From: Williams, Stephen (ENV - HEM)
Sent: 18 March 2013 15:02
To: 'planning@ribblevalley.gov.uk'
Subject: FAO Stephen Kilmartin Application No. 3/2013/0137

Your ref District Planning ref 3/2013/0137
 Our ref PRW 09-14

PUBLIC FOOTPATH NO. 30 WHALLEY, RIBBLE VALLEY BOROUGH

Client: Commercial Estates Group			
Project: Whalley			
Title: Parameter Plan			
Status:			
Designed:	Drawn: HE	Checked: AR	
Scale: 1:1000@A1	Date: 1/02/13	Approved: AR	
Drawing No: PL1158.3.M.101			Revision: A

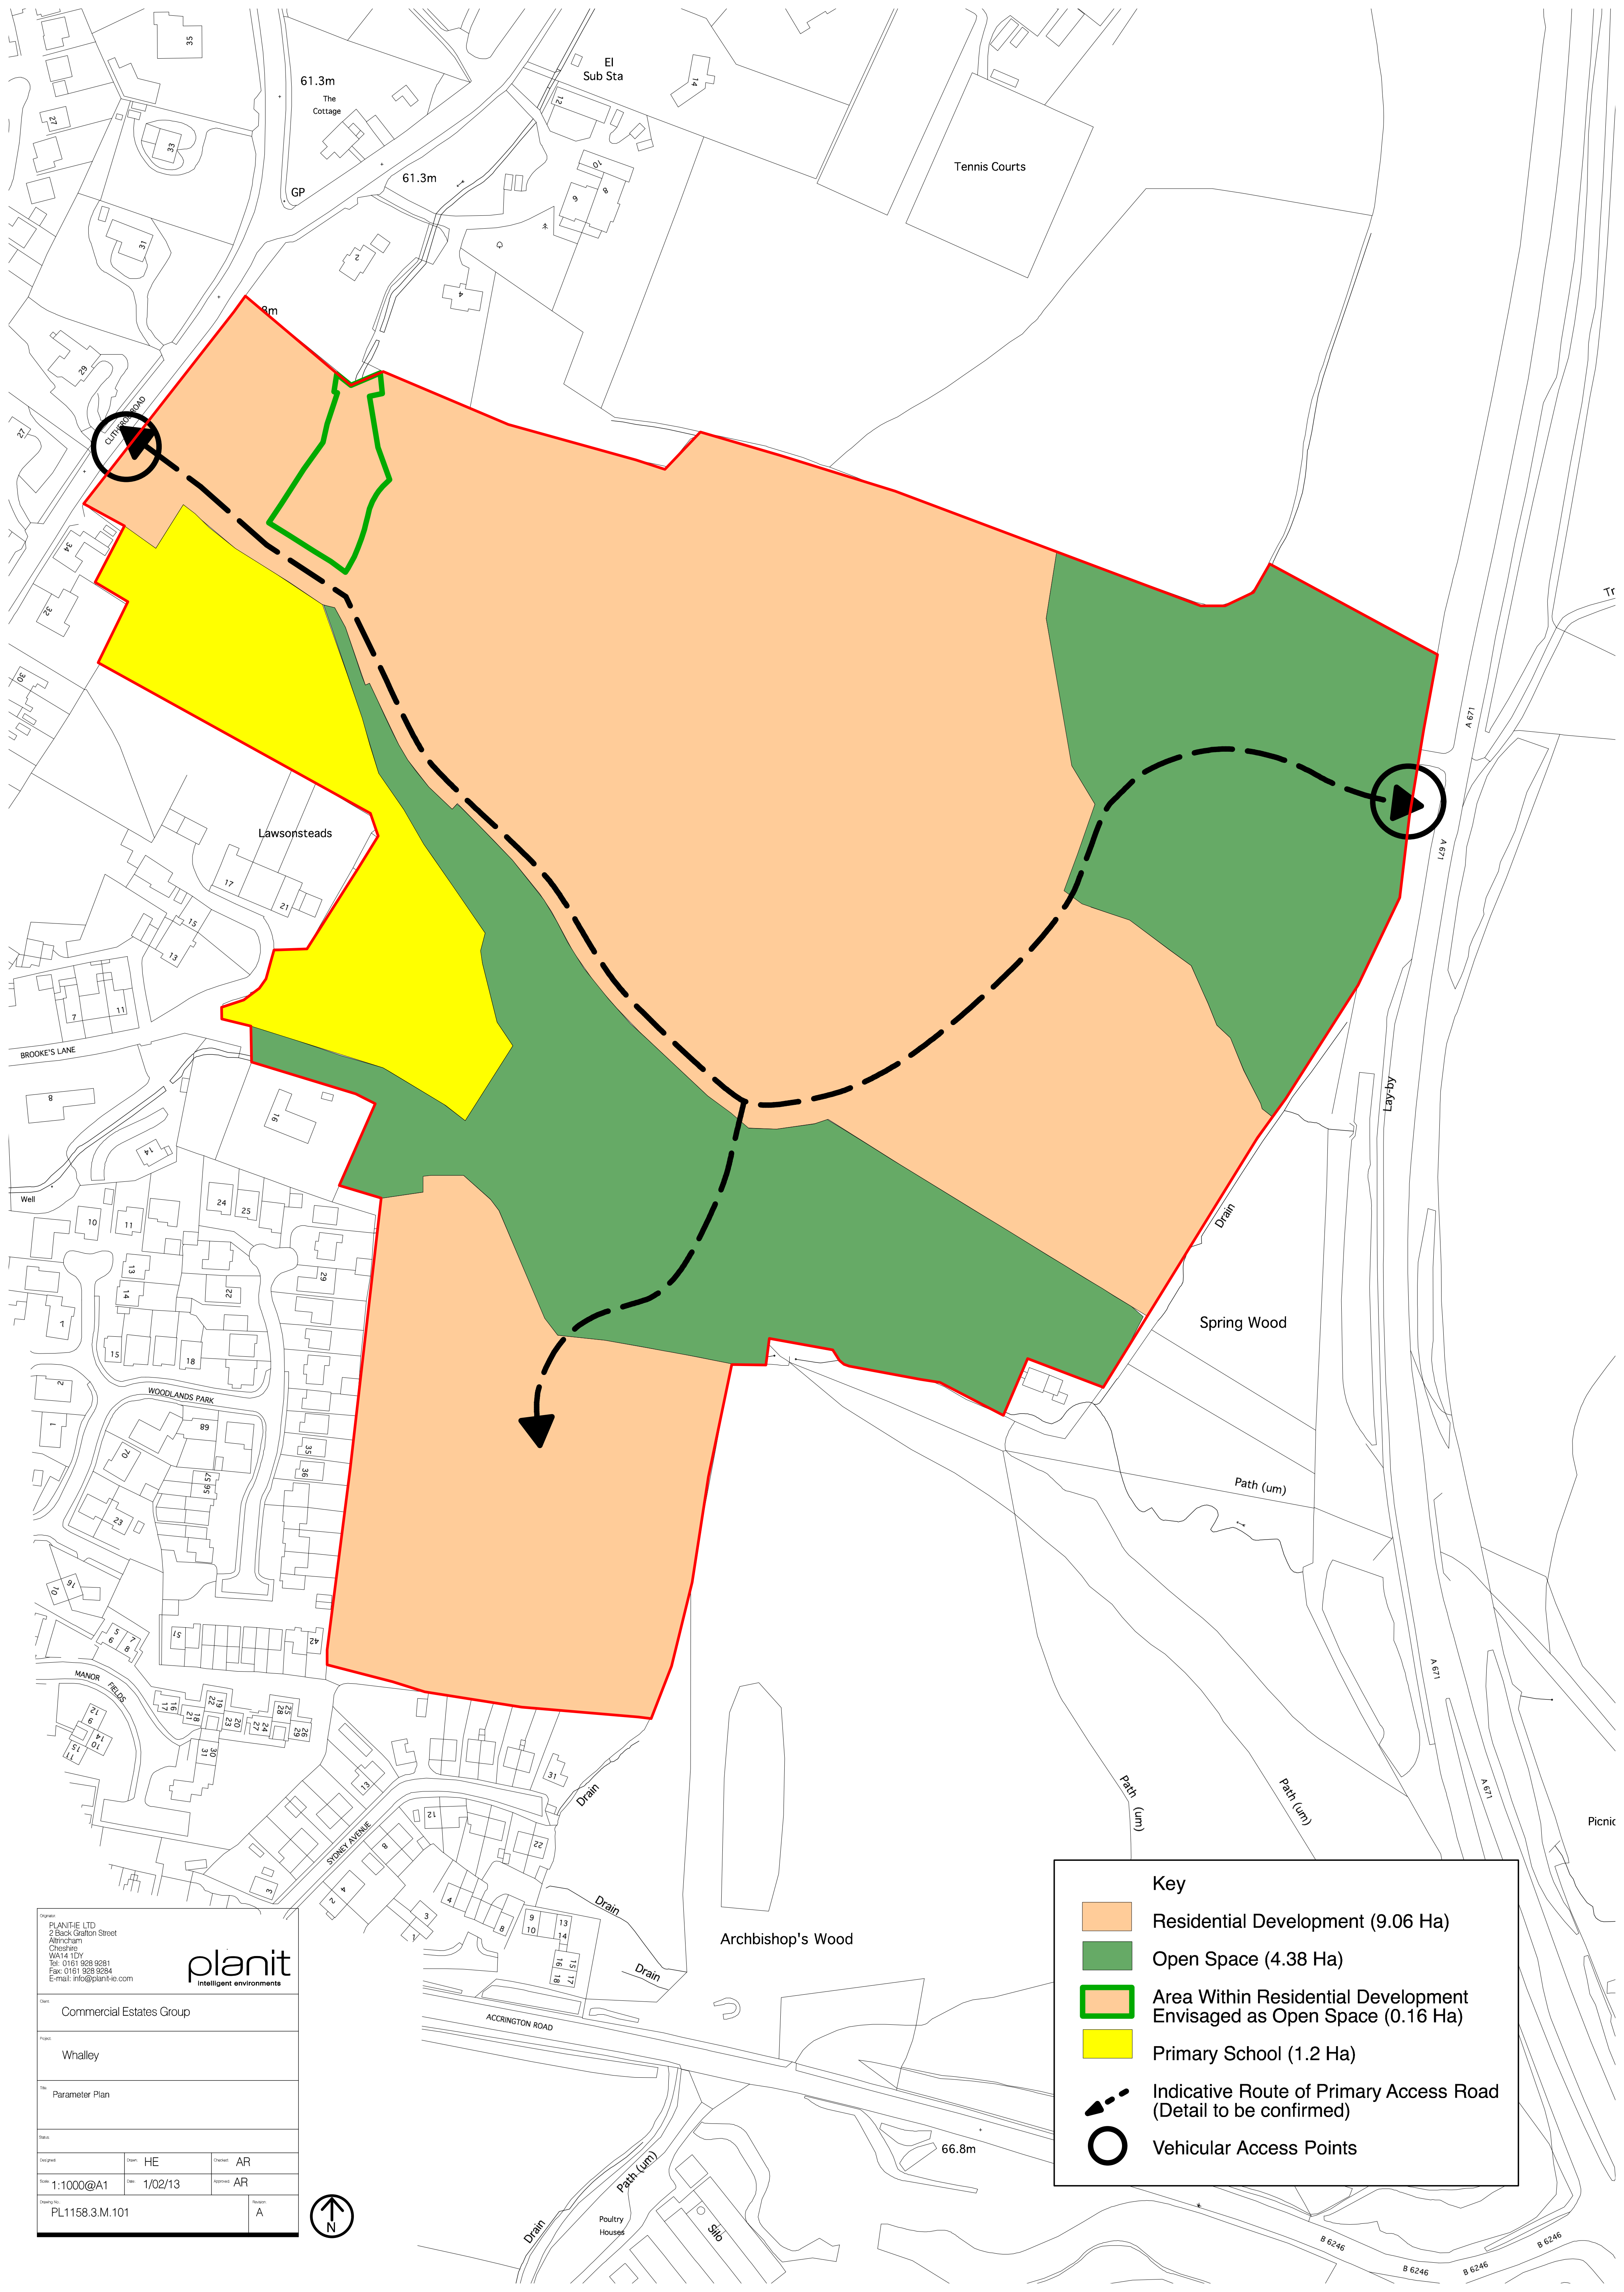
From the plan that I have been able to inspect it is apparent that the application area incorporates Public Footpath No. 30 Whalley. I attach an extract of the Definitive Map of Public Rights of Way (First Review) that shows the above public footpath. From the plans that I have been able to inspect on the Ribble Valley Borough website it is not clear whether the application will affect the above Public Footpath though it appears from the parameter plan that the footpath will be crossed by a primary access road.

Public Rights of Way must not be obstructed during the proposed development. It is the responsibility of the landowner to ensure that the necessary procedures are followed for the legal diversion of the Public Right of Way if this should be necessary. The granting of planning permission does not constitute the diversion of a Definitive Right of Way. If it is necessary for Public Rights of Way to be temporarily diverted or temporarily closed, this is the responsibility of the landowner to ensure that this is done following the appropriate legal procedures. A temporary closure will only be granted where it is the intention to re-open the right of way upon expiration of the closure on the route recorded on the Definitive Map of Public Rights of Way.

The development must not commence until the necessary procedures are in place, either allowing the development to take place without affecting the right of way as recorded on the Definitive Map of Public Rights of Way and subsequent diversion orders and side roads orders, or if it is necessary to divert the above listed Public Rights of Way, then the necessary Orders must be confirmed prior to construction to avoid enforcement action should the above Public Footpath become affected. There is no provision under the Town and Country Planning Act 1990 to allow a retrospective diversion of paths that are already affected by either partially completed or completed development.
